# CITY OF ALBUQUERQUE

June 10, 2019

**RE: 8500 Glendale Ave. NE**  
**Grading and Drainage Plan**  
**Engineer's Stamp Date: 05/28/19**  
**Hydrology File: B20D067**

DON BRIGGS Engineering LLC

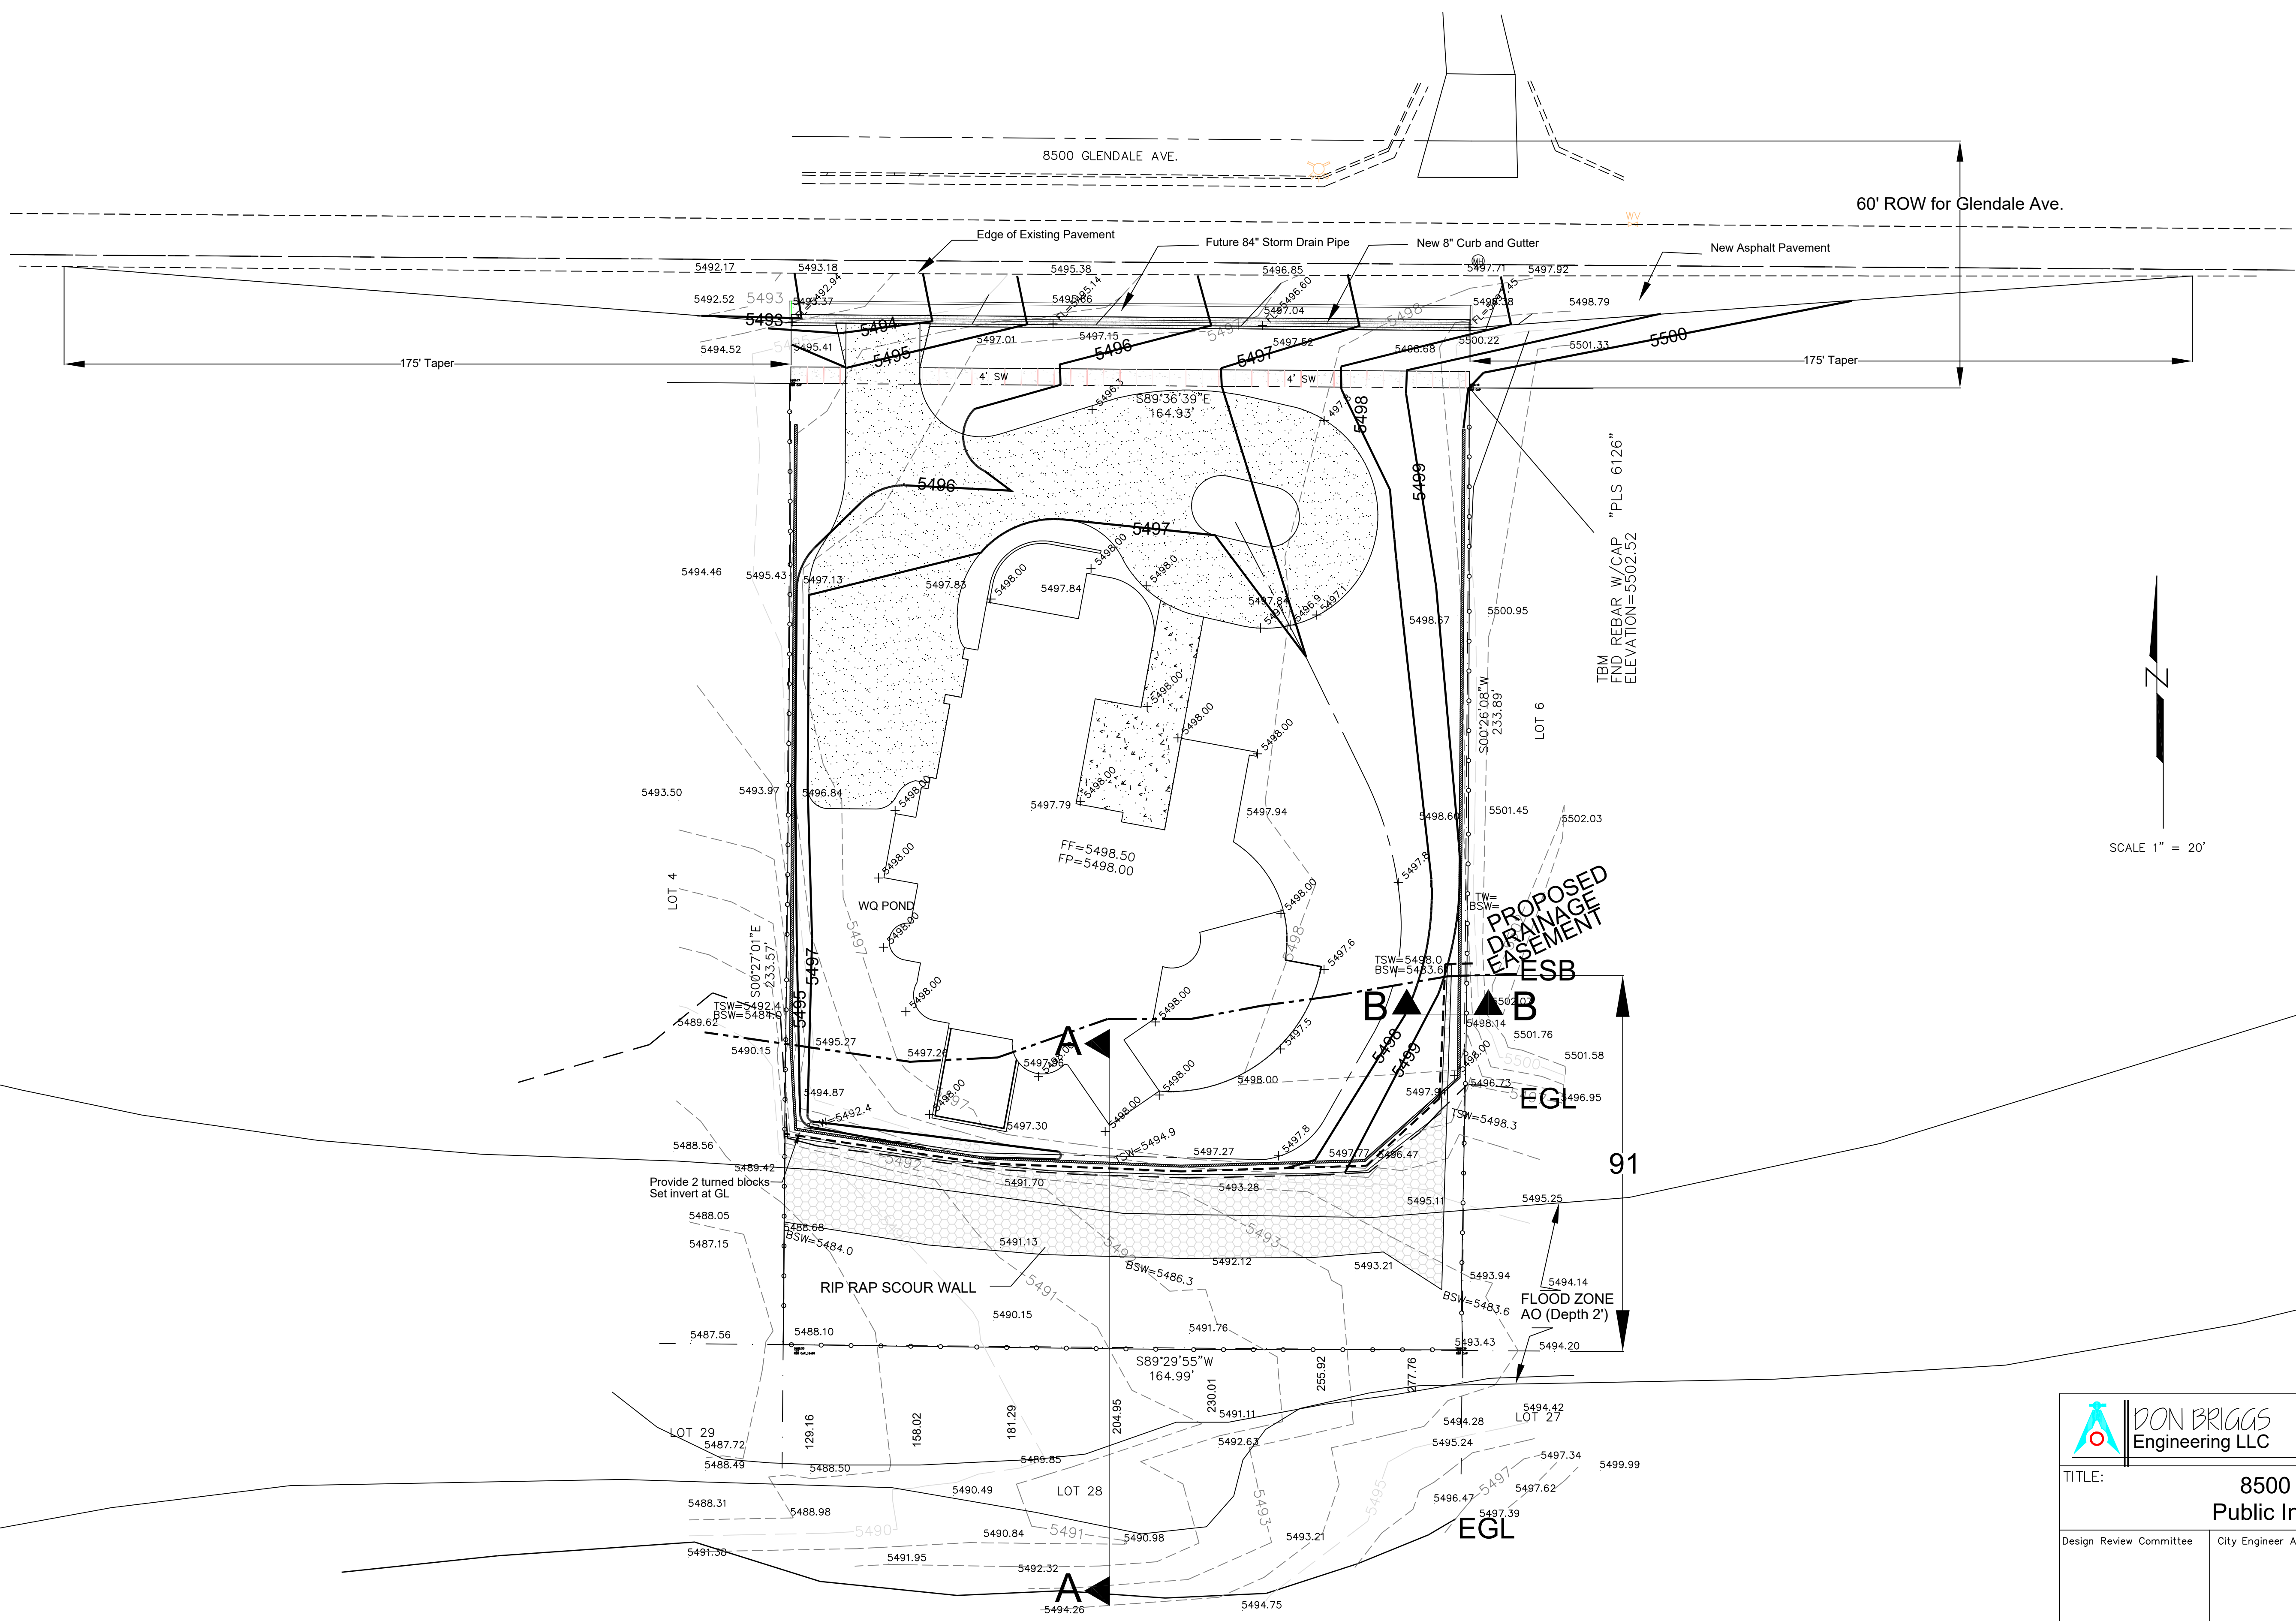
2. At the northwest and northeast corners of the property, there are proposed grading on the adjacent properties. Written approvals from both of the adjacent property owners are required prior to Building Permit approval.
